# Tallawong Station Precinct South

Response to Submissions: Engineering Items

Client: Landcom

17-Oct-2018

60558549-SHT-00-0000-CI-0802

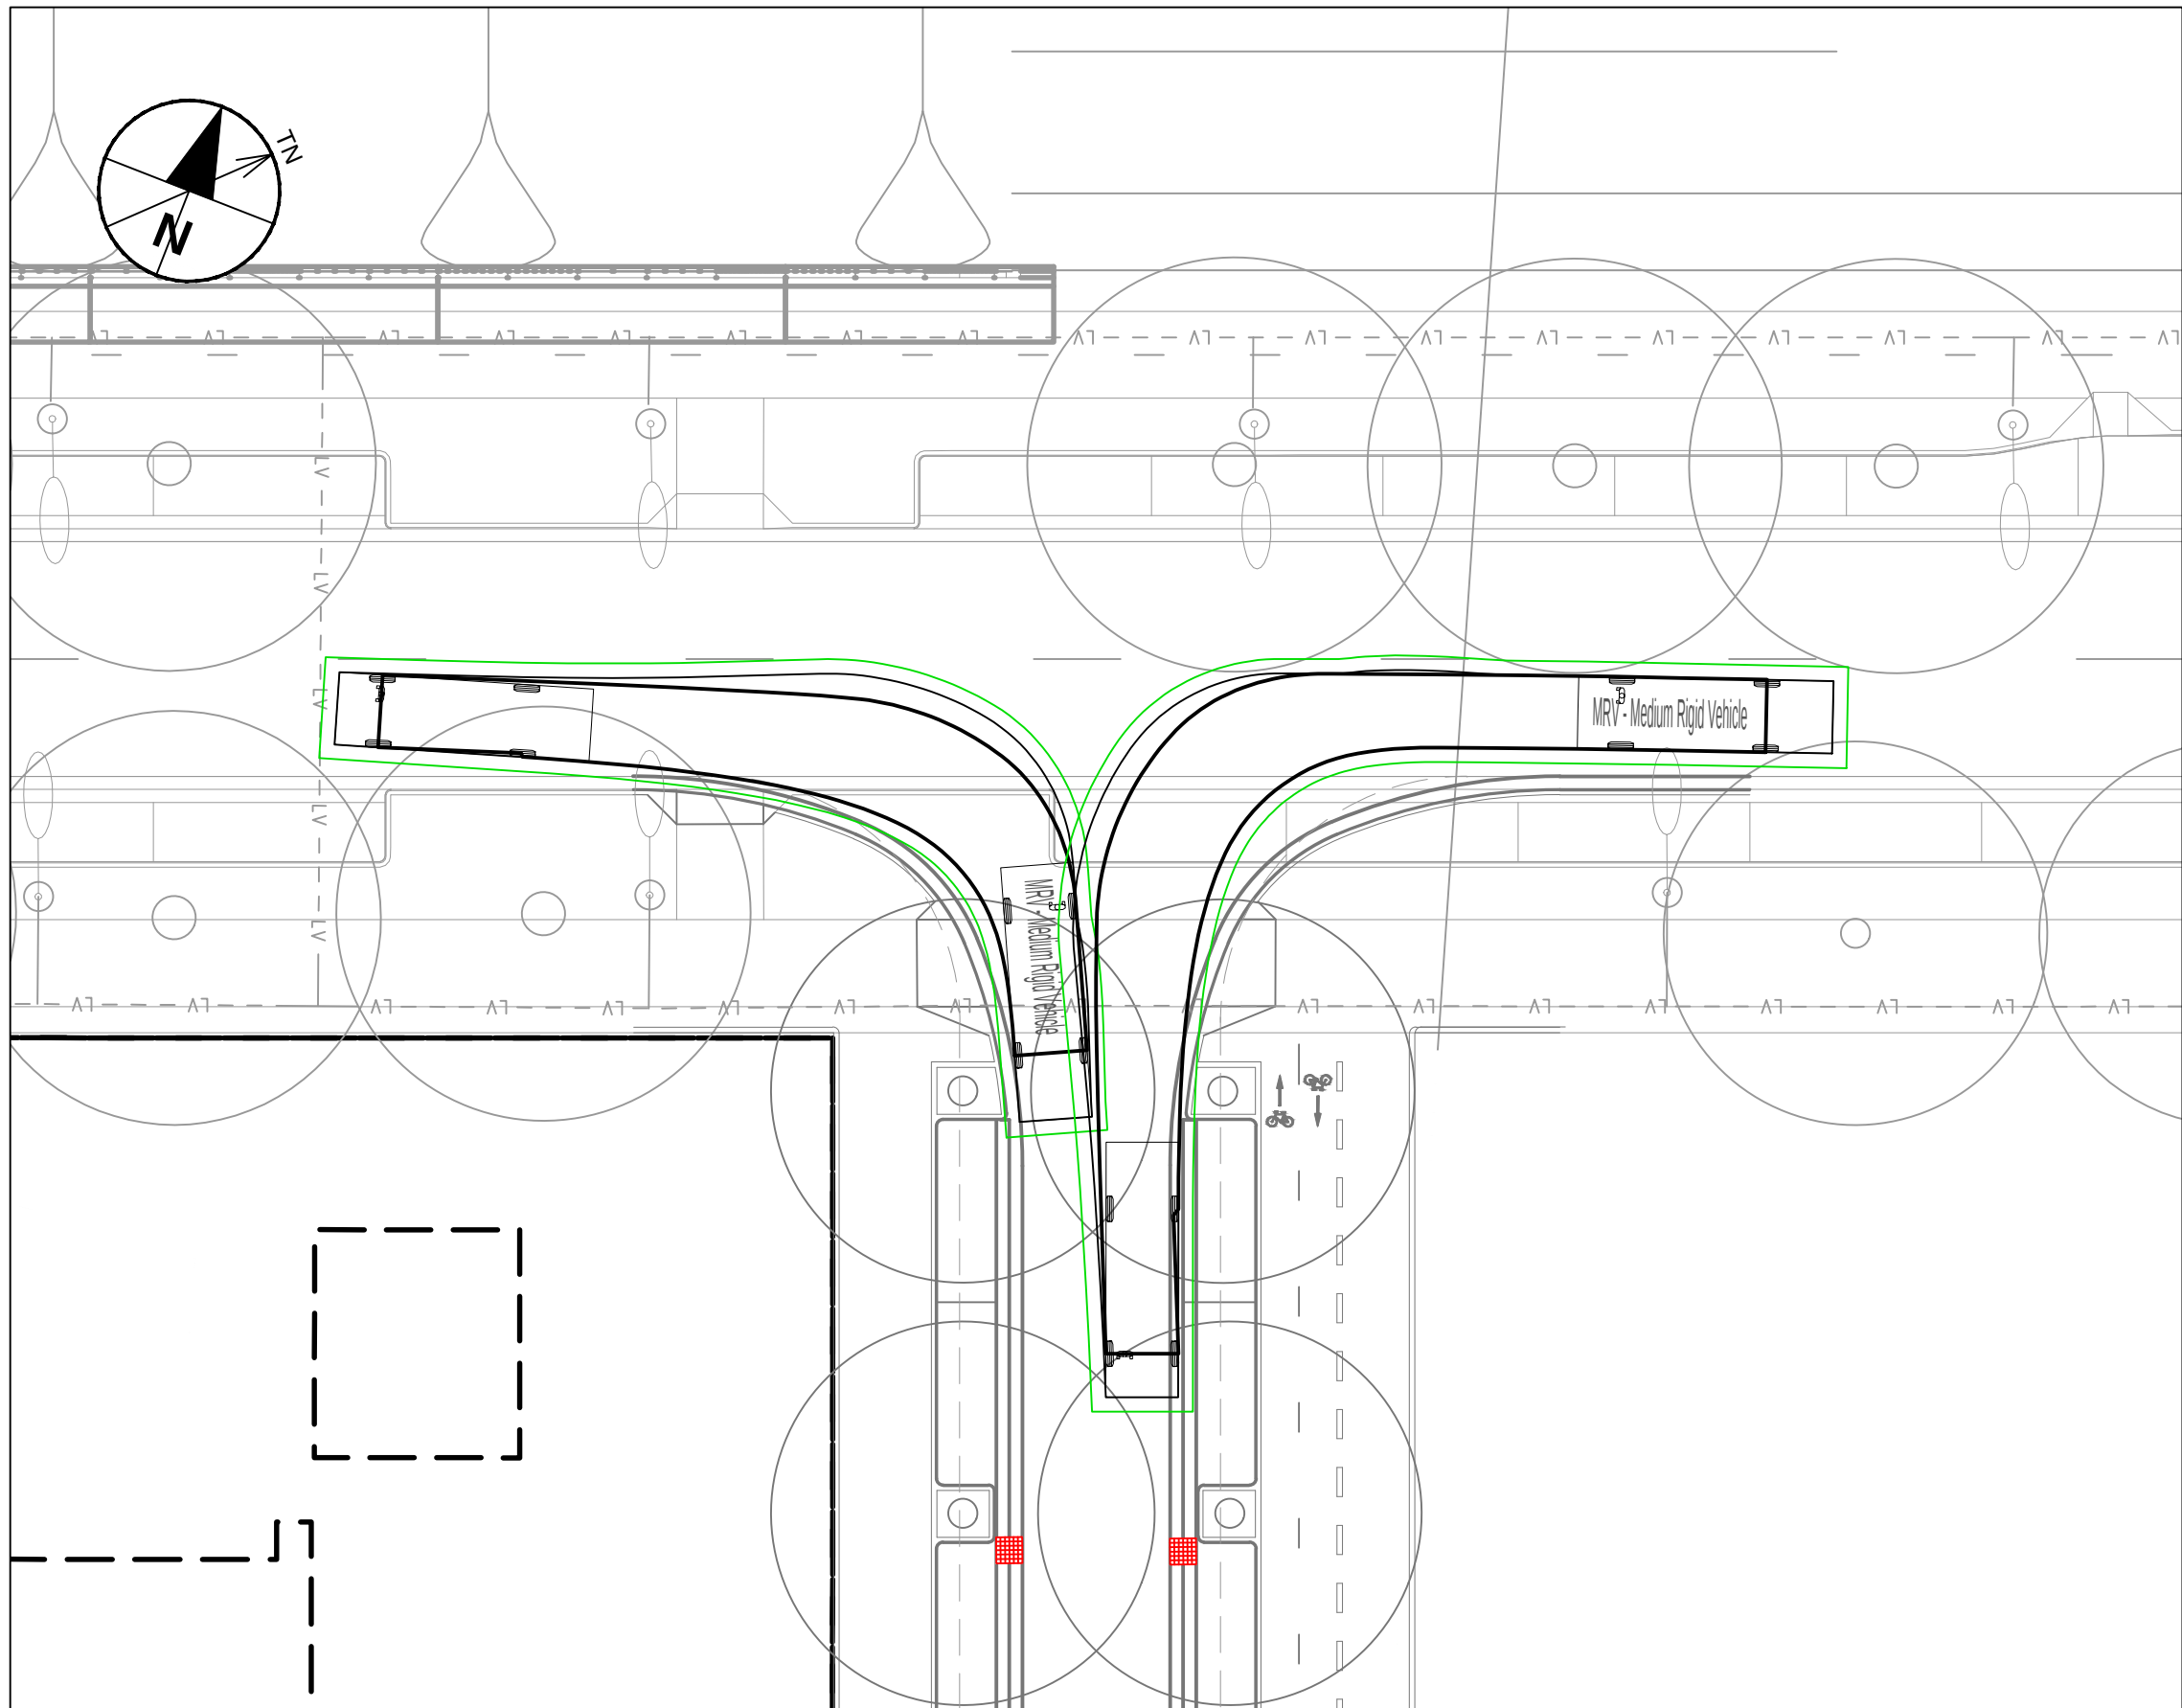
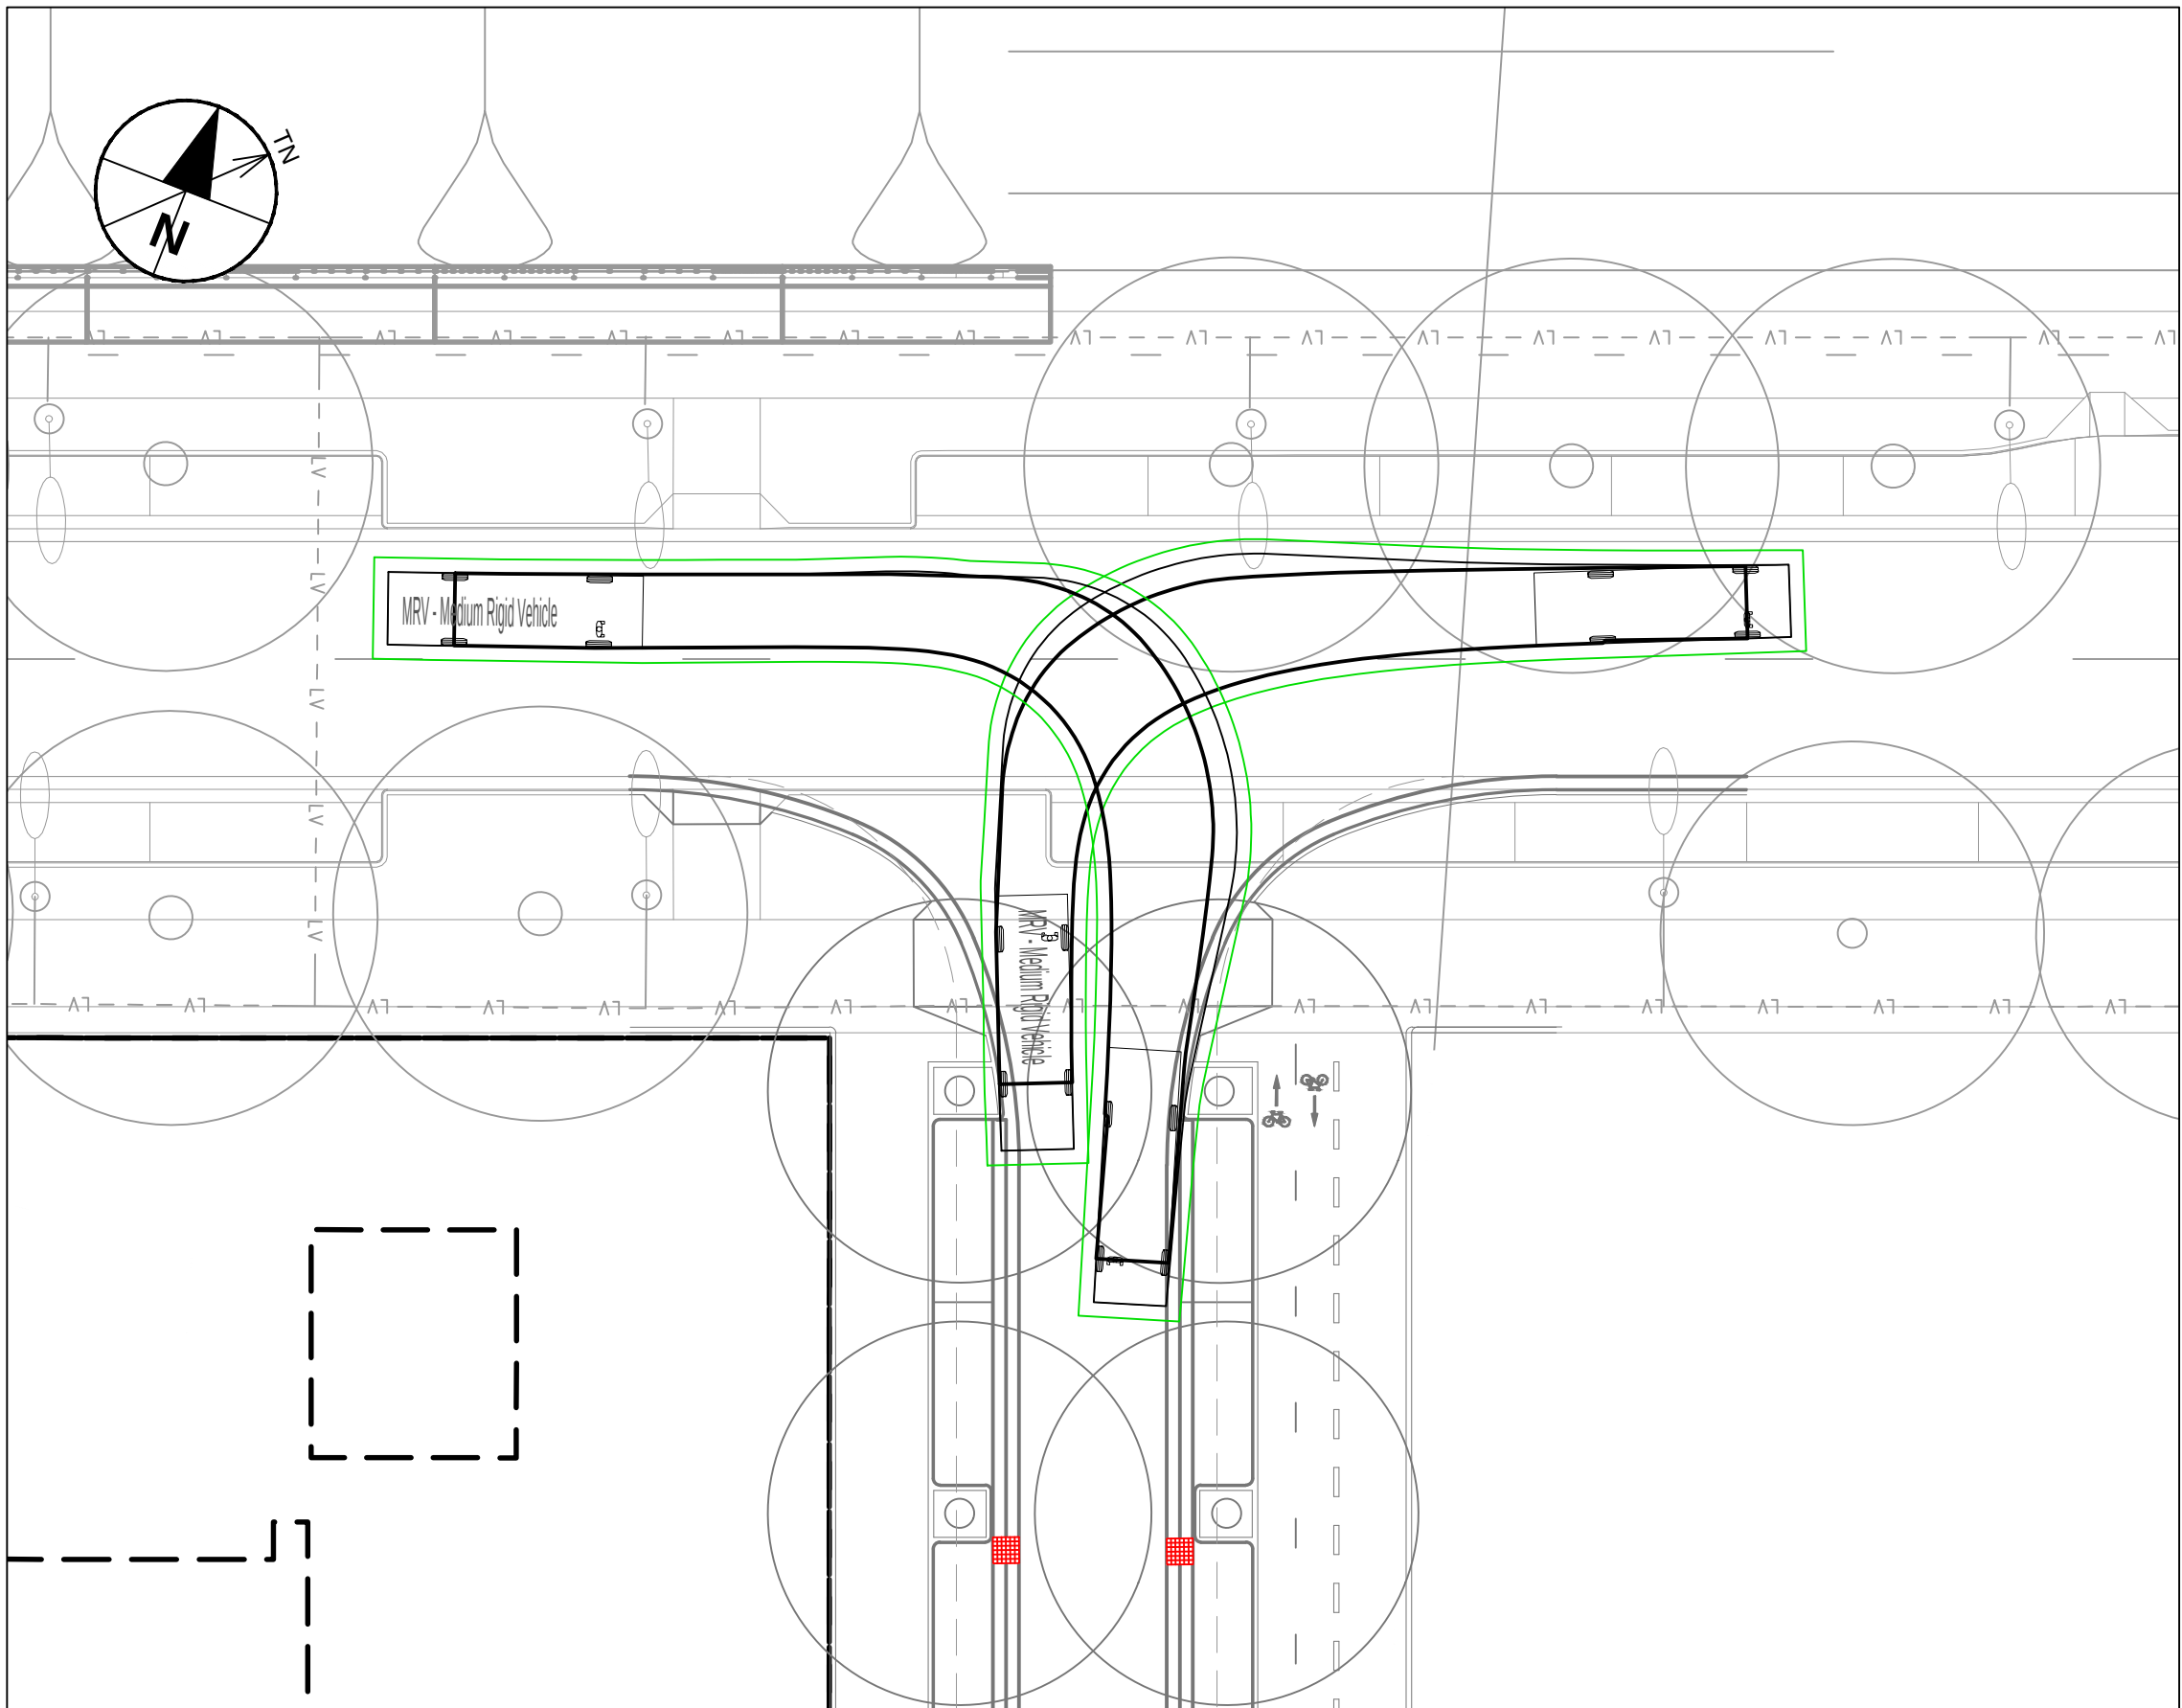
*vi. Demonstrate that the proposed 3.0m lane widths are adequate for larger vehicles such as buses, refuse and service vehicles*

These tracking plans demonstrate that the proposed 3.0m lane widths are adequate for larger vehicles such as buses, refuse and service vehicles.
